RE: Westside Acres Short Plat SP-10-00011

Thank you for the opportunity to comment on the Westside Acres Short Plat, SP-10-00011.

SUBJECT: Westside Acres SP-10-00011

SHEET 1 OF 2

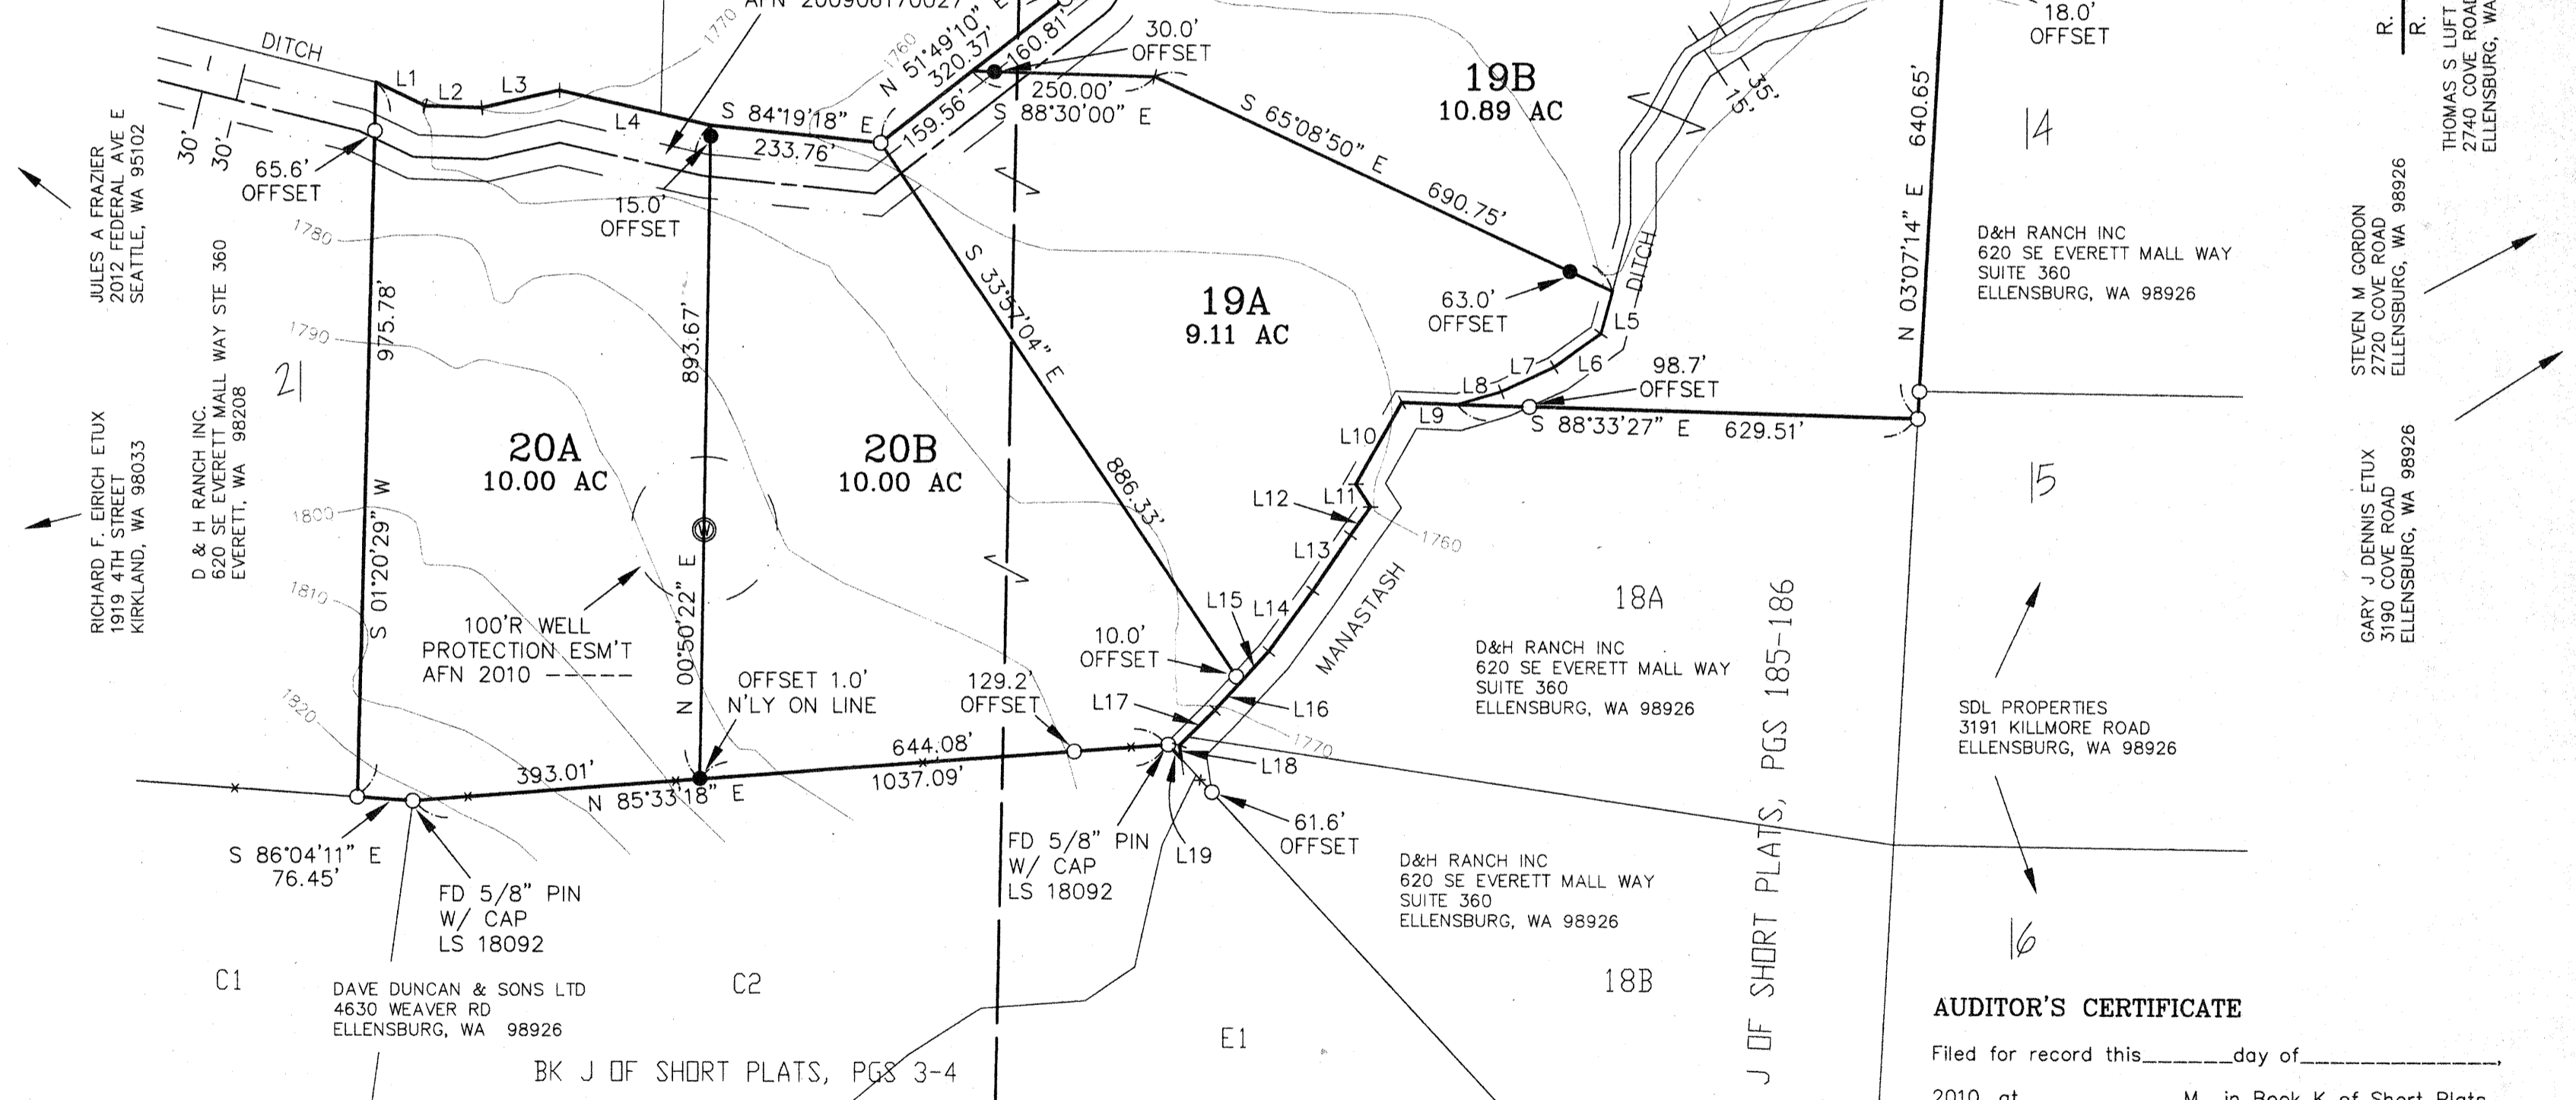
3. Private Road Improvements: Access from Silverton Road along the private access easement 'Q' to Robinson Canyon Road shall be constructed as a Low-Density Private Road. See Kittitas County Road Standards, 9/6/05 edition.

- a. Access easements shall be a minimum of 60' wide. The roadway shall have a minimum width of 20', with 1' shoulders, for a total width of 22'.
  - b. Minimum centerline radius will be 60'.

- c. The surface requirement is for a minimum gravel surface depth of 6".
  - d. Maximum grade is 12%.
  - e. Stopping site distance, reference AASHTO.

4. Cul-de-Sac: A cul-de-sac turn-around having an outside right-of-way or easement diameter of at least 110 feet shall be constructed at the closed end of all dead-end roads serving 3 or more lots. The driving surface shall be at least 96 feet in diameter. Cul-de-sacs must also conform to the requirements specified by the 2006 International Fire Code. Contact the Fire Marshal regarding any additional cul-de-sac requirements.
